Response to Planning application from Hertfordshire County Council (T and CP GDP Order 2015)

District ref: 6/2022/2226/FULL
HCC ref: WH/14177/2022
HCC received: 12 October 2022
Area manager: Matthew Armstrong
Case officer: Melvin Andrews

20 BLACK FAN ROAD WELWYN GARDEN CITY AL7 1QA

Installation of a "private-wire" electricity cable between the Energy Centre, Tewin Road and Colt Technology Services Group Limited (Option 1).

Title: **Proposed Cable Route Option 1**

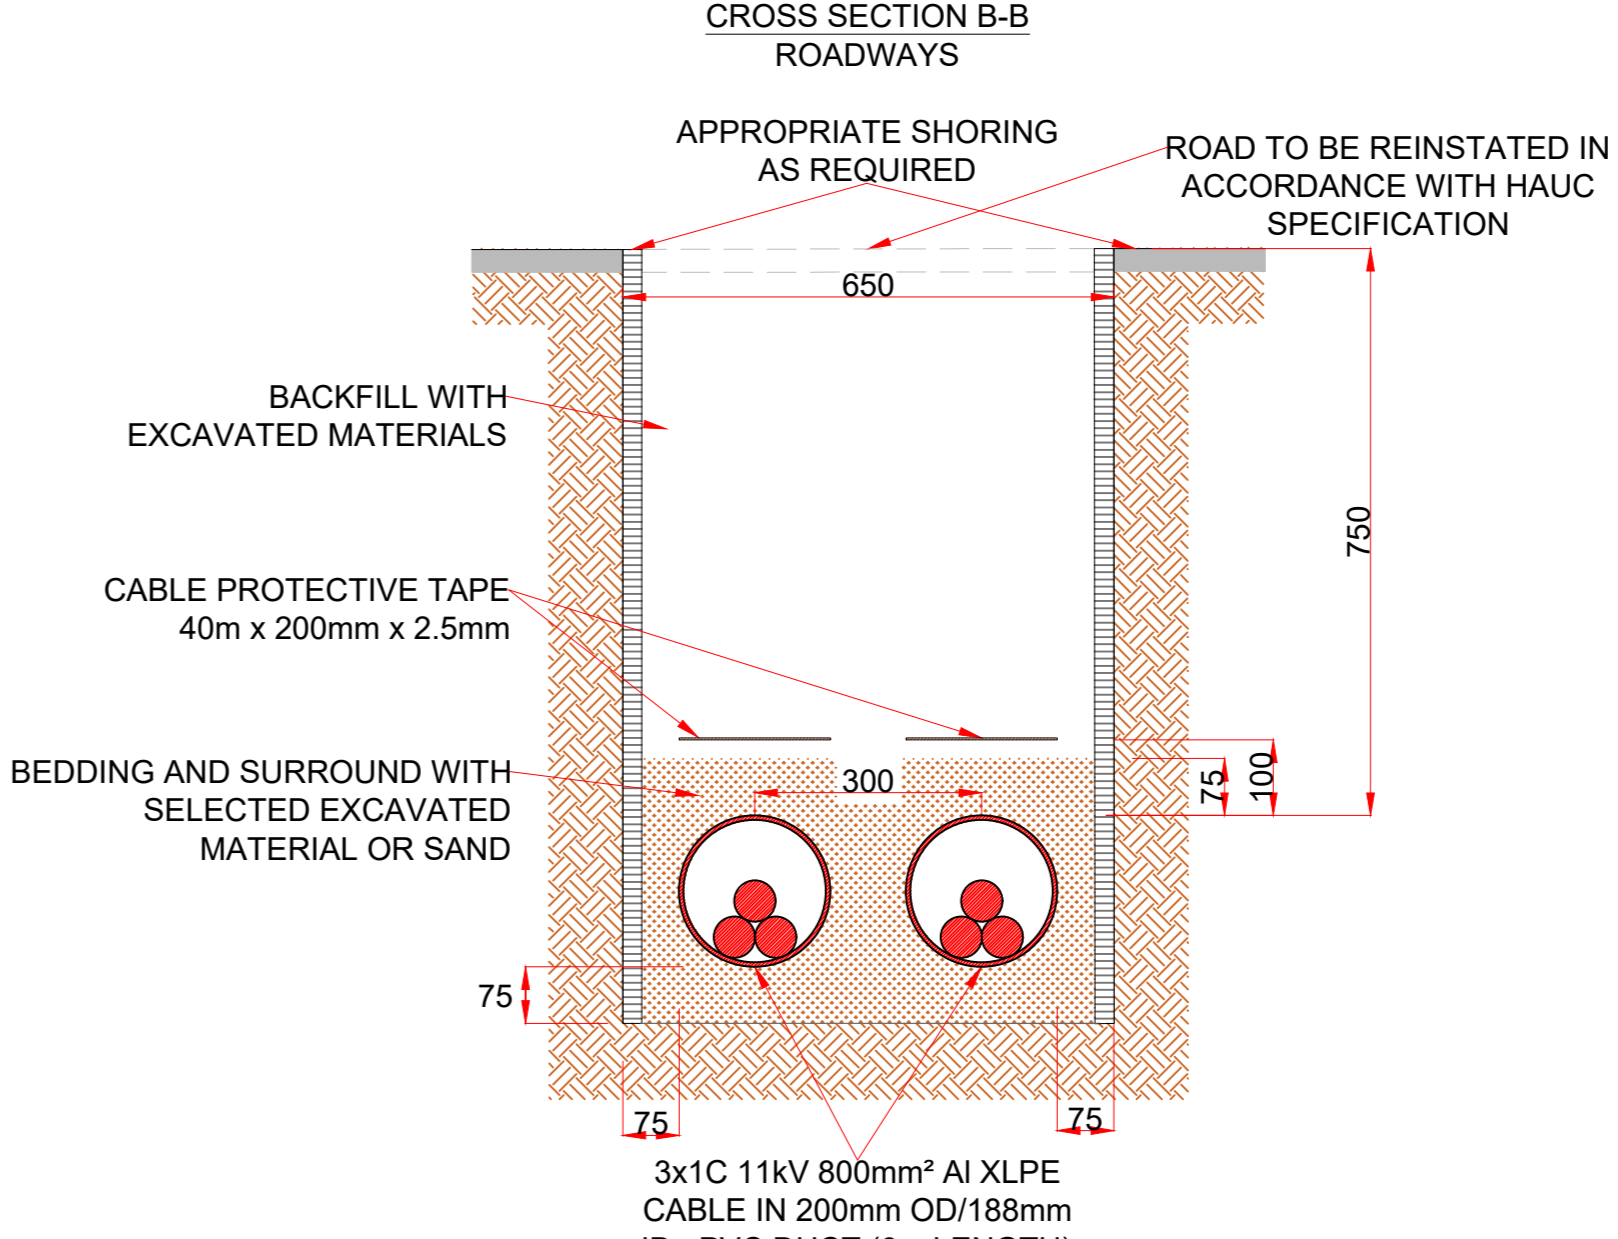
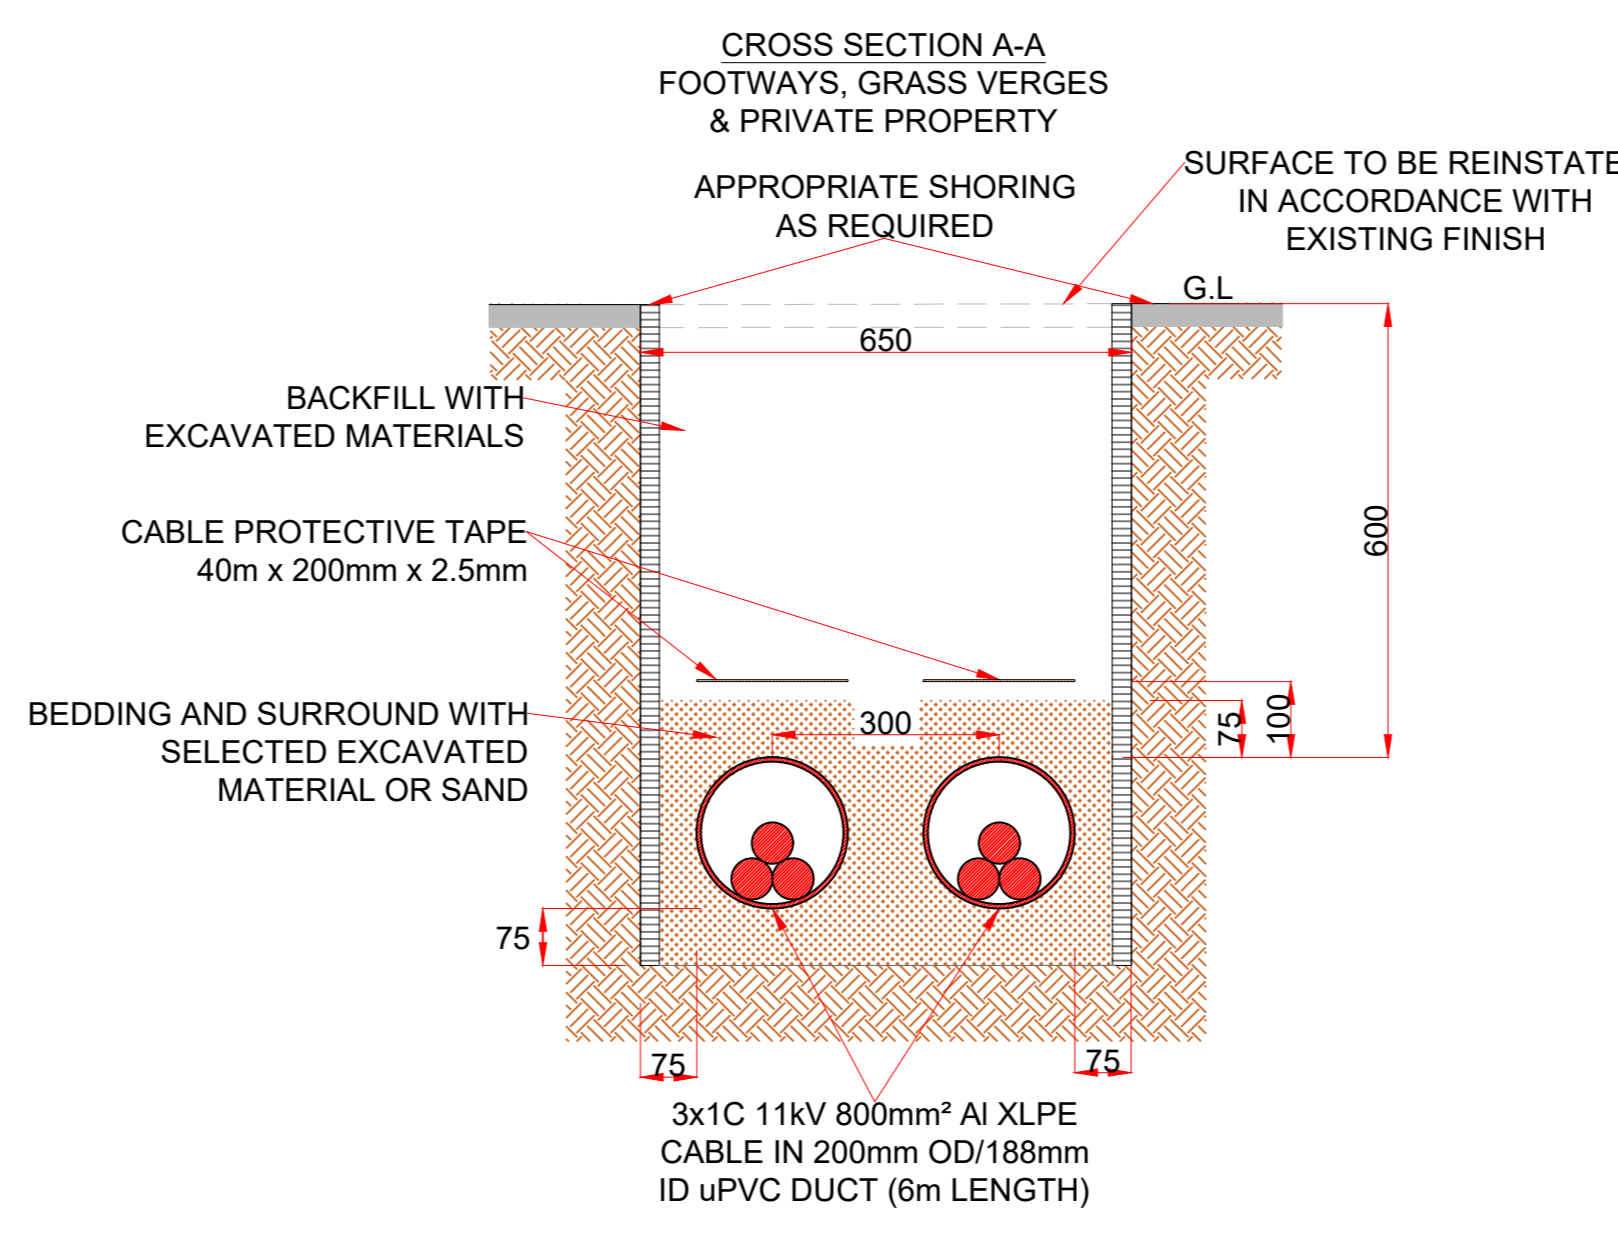
All of the routes proposed in plans 1-4 will have an impact to the Welwyn Garden City Fire Station, this is located on Bridge Road East on the junction with Woodfield Road. The applicant and subsequent traffic management plans should take careful consideration around planning of works at the entrance to the station so that they can maintain access at all times as this will be required 24/7.

Based on the plans provided I would say that the route proposed in plans 1-4 is the more preferential as it's the most direct, whereas option 5 utilising Black Fan road has a few schools it would need to account for and could occupy the network for longer due to being a larger scope of works.
